KIRKLEES METROPOLITAN COUNCIL INVESTMENT & REGENERATION SERVICE

Reference No:	2026/62/90656/E
Site Address:	6, Nelson Street, Dewsbury, WF13 1NA
Description:	Replacement of specified external doors and windows with like-for-like units (Listed Building within a Conservation Area)
Recommending Officer:	Faiza Bano

Officer Report – 2026/90656

Timber Sash Window Section Detail
Existing (1:5)

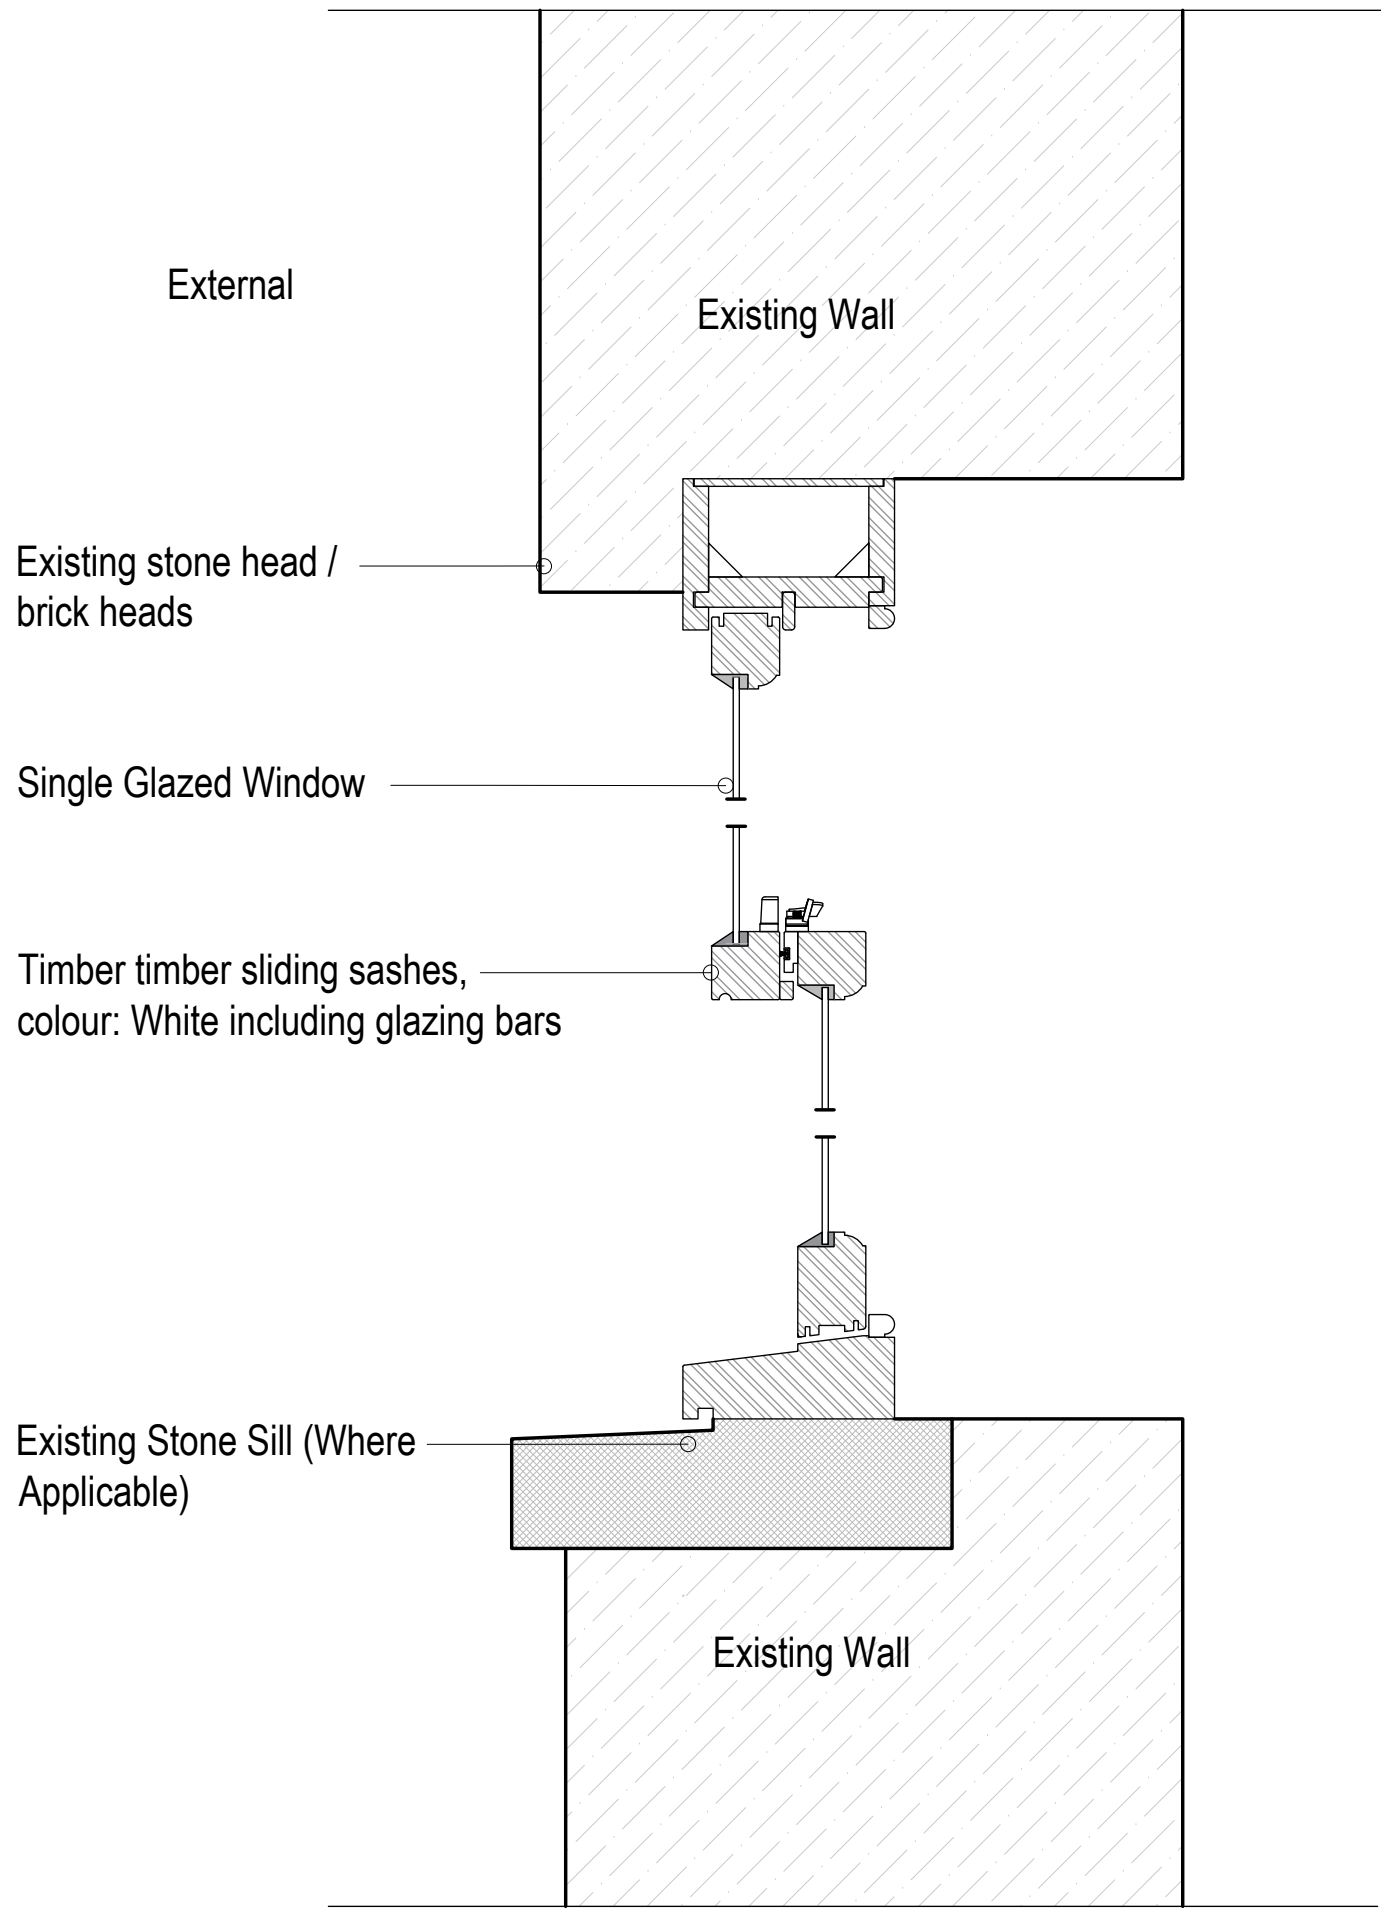
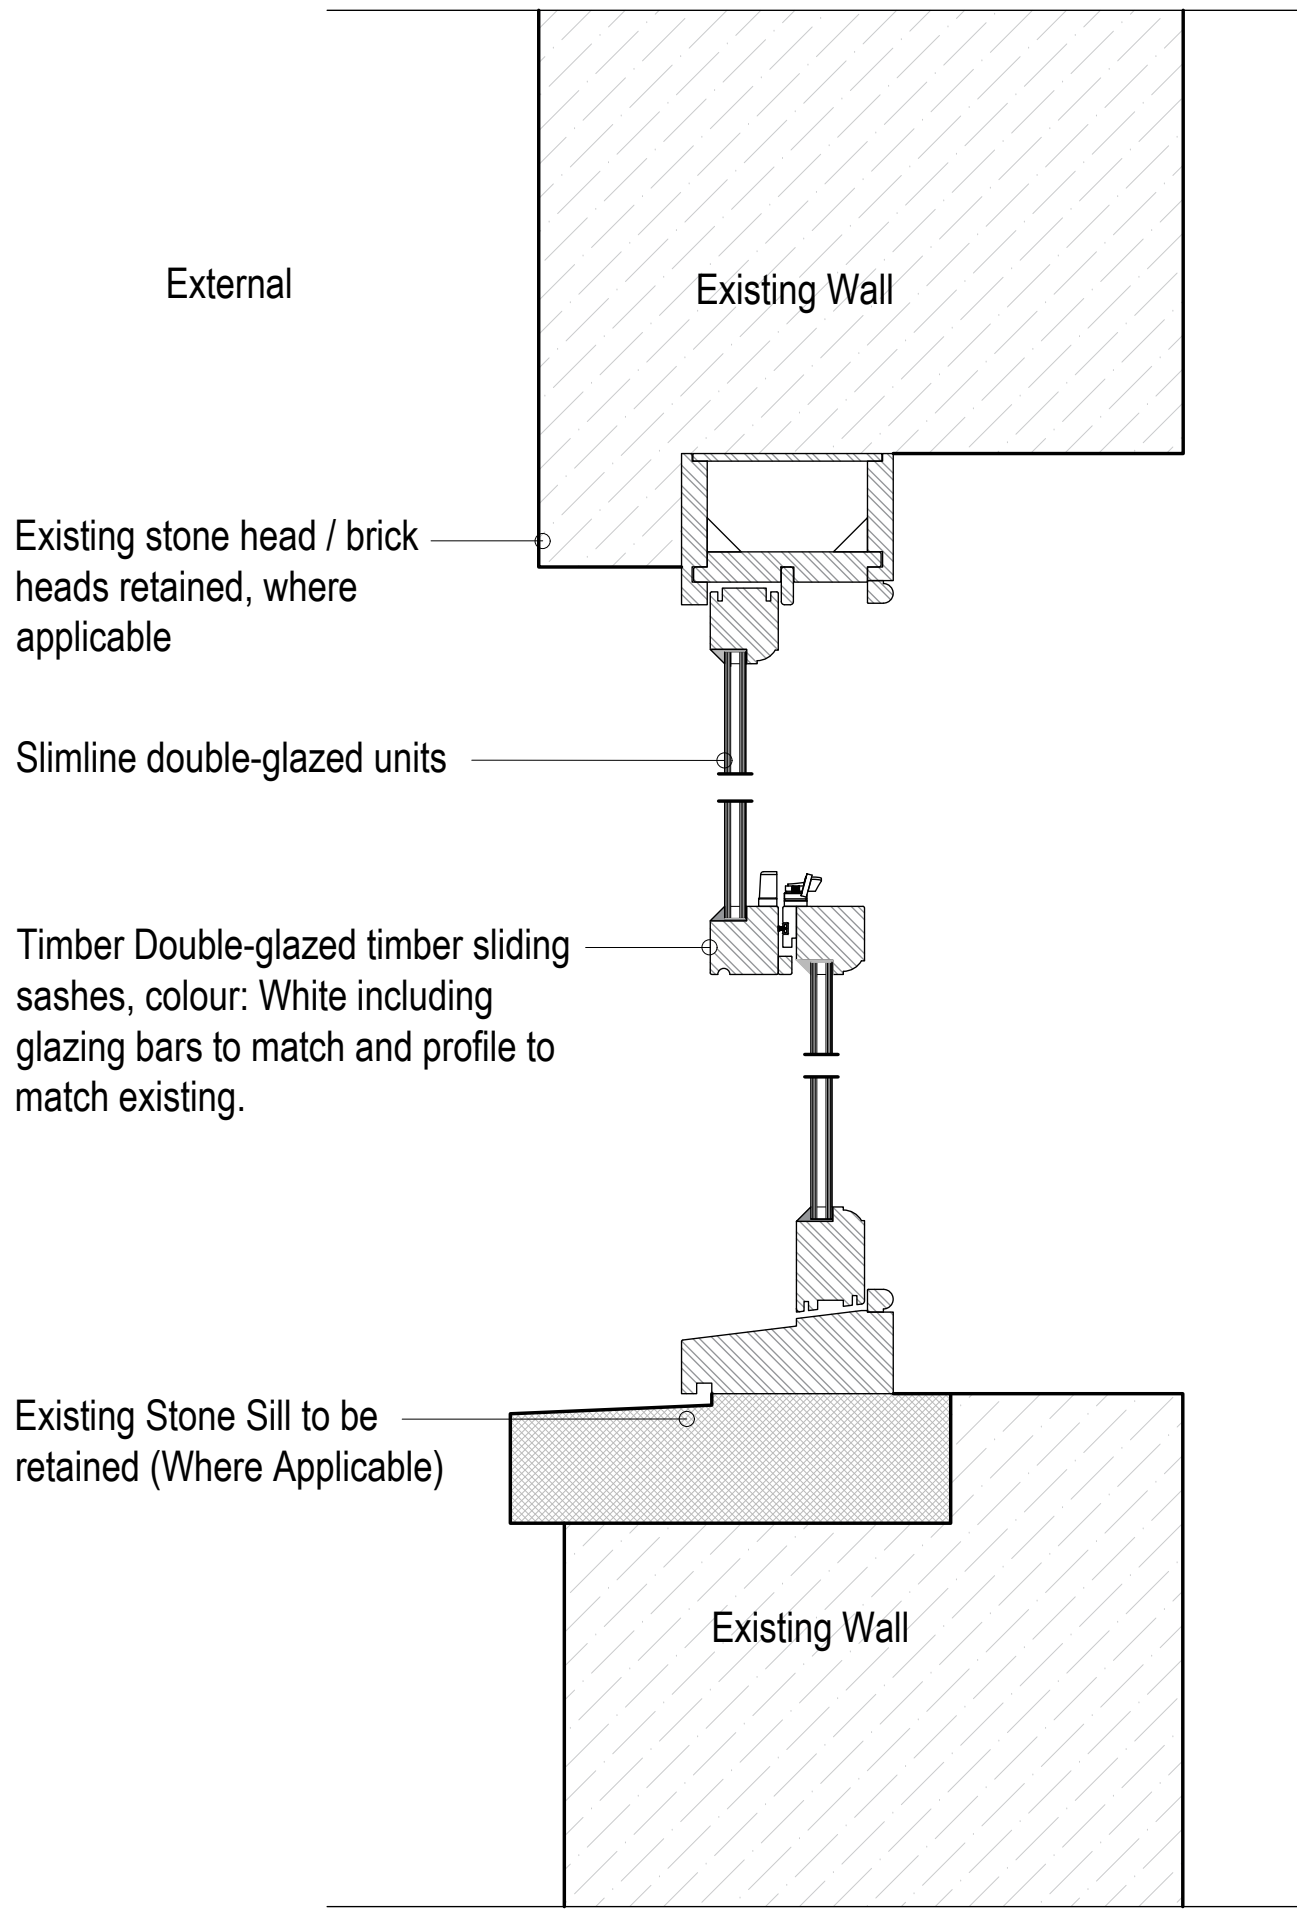
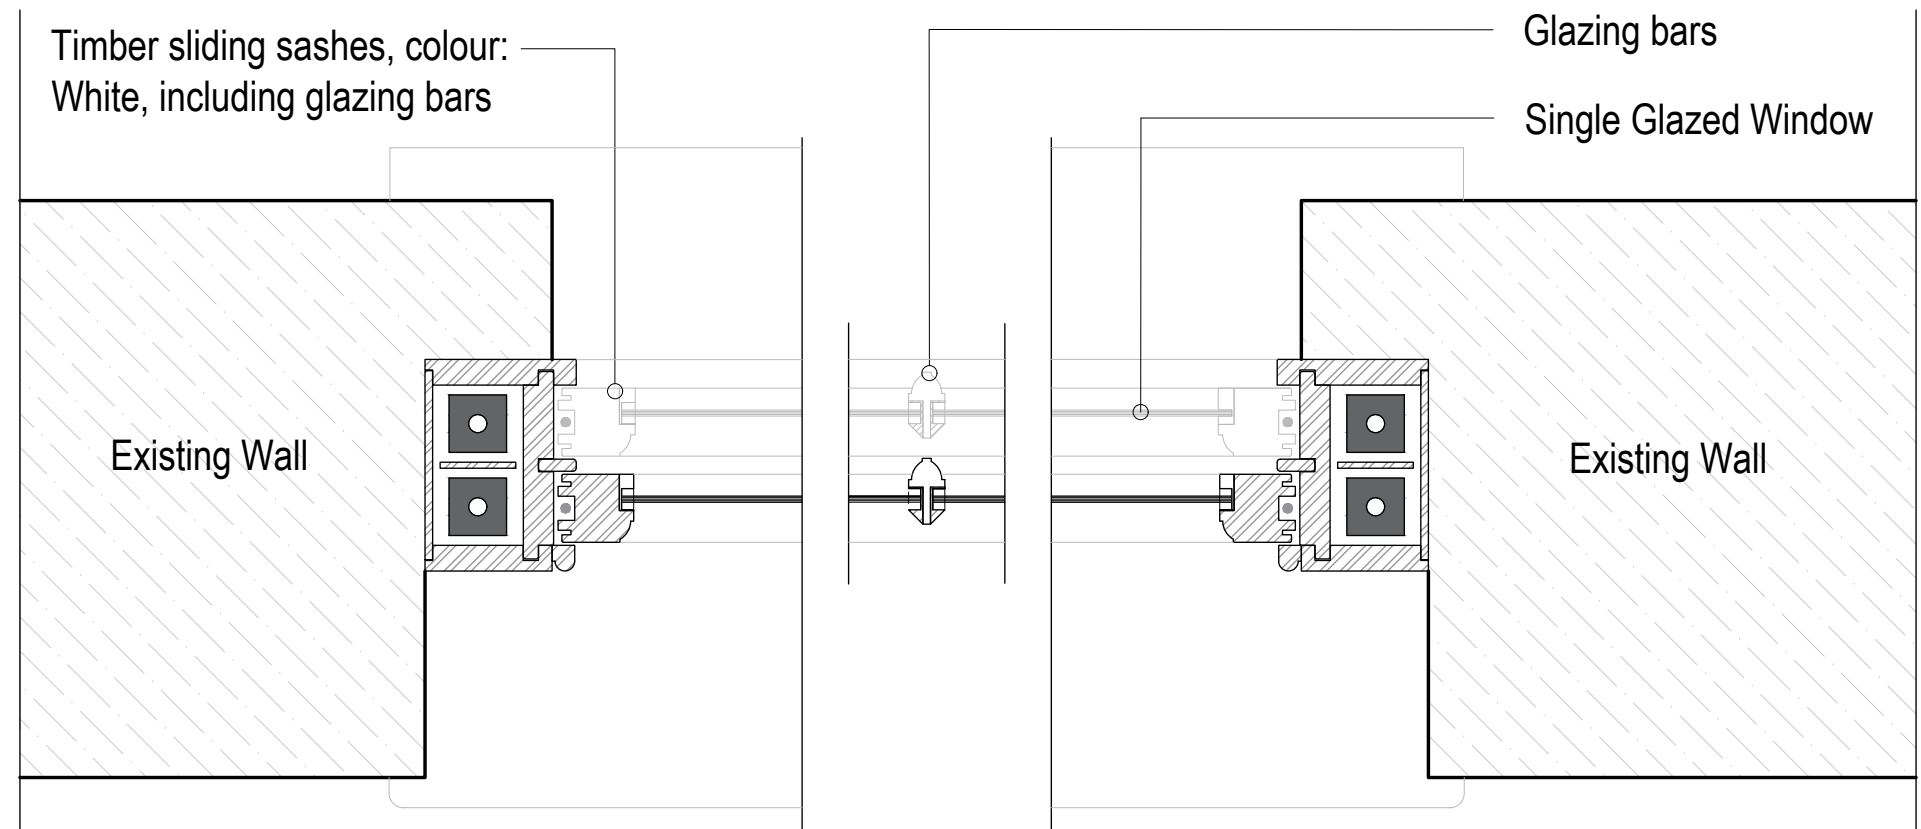
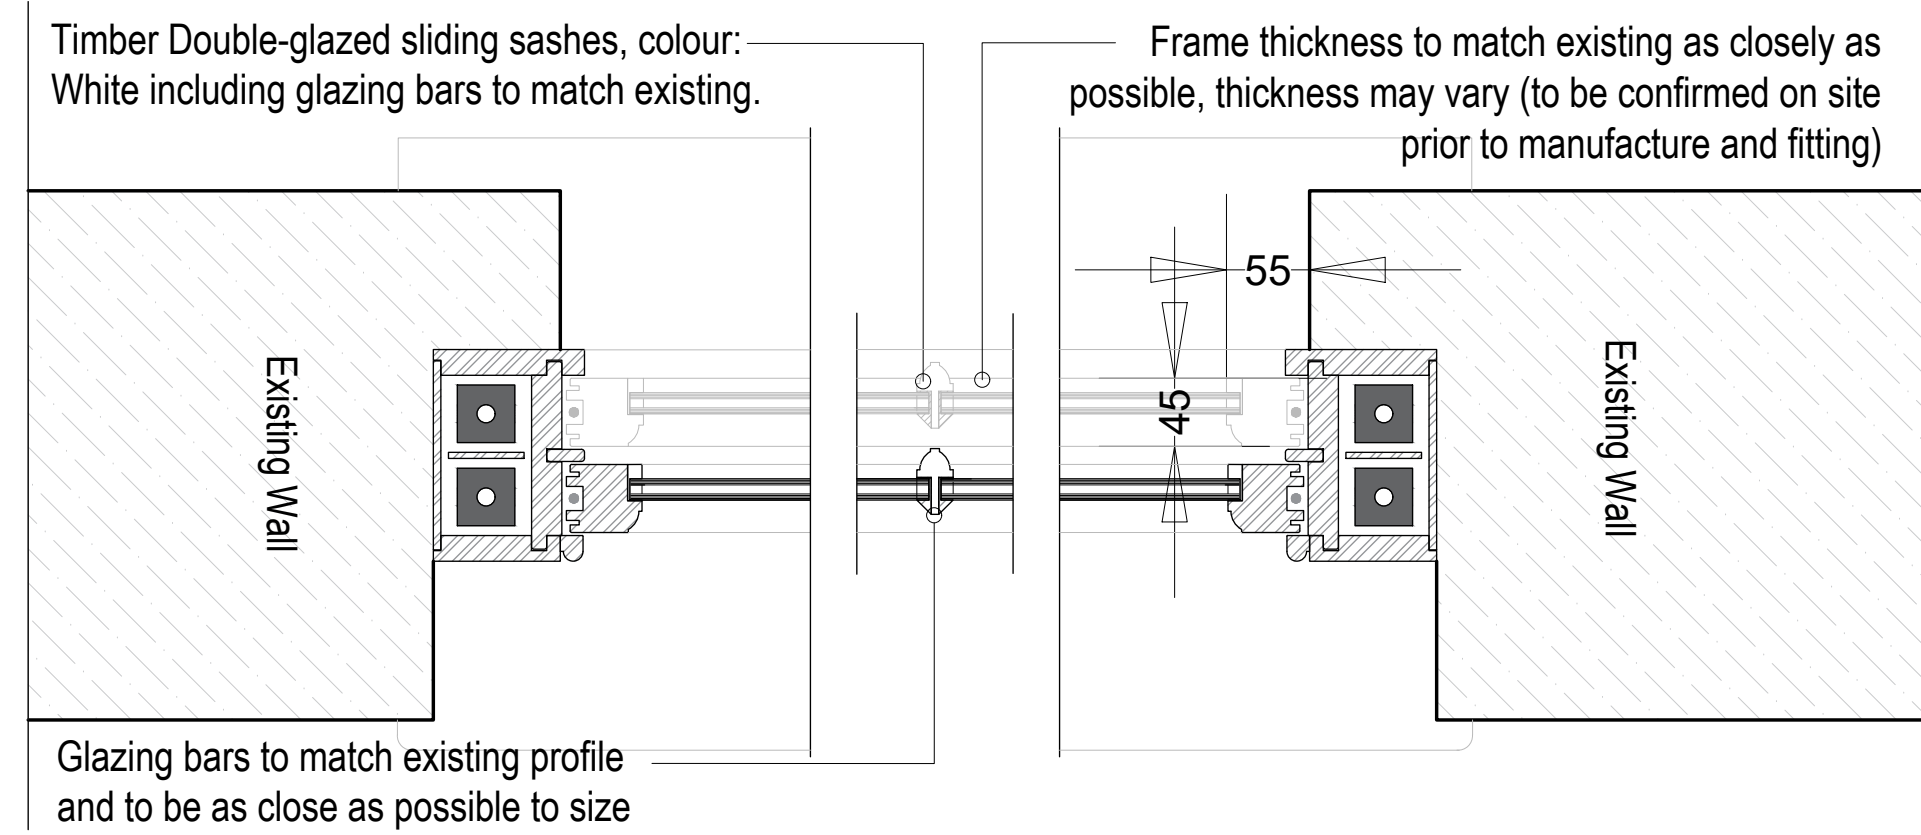
3. Notwithstanding the approved plans all windows shall match the existing joinery details in terms of material, profiles, detailing, dimensions, albeit with an increase in the internal section sufficient to accommodate slim double glazing. All slim double-glazed units shall have a maximum of 4mm glass with an 8mm gap with black spacer bars. New opening windows shall be sliding sashes. Visible trickle vents shall not be permitted. All new window frames shall be set back in the reveal by 75-100mm or to match existing and shall not be fitted flush with the external wall
Reason: In the interests of visual amenity and safeguarding the significance of the heritage asset pursuant to the requirements of Sections 72 and 16 of the Planning (Listed Buildings and Conservation Areas) Act 1990, policies LP24 and LP35 of the Kirklees Local Plan and policies contained within chapter 20 of the National Planning Policy Framework
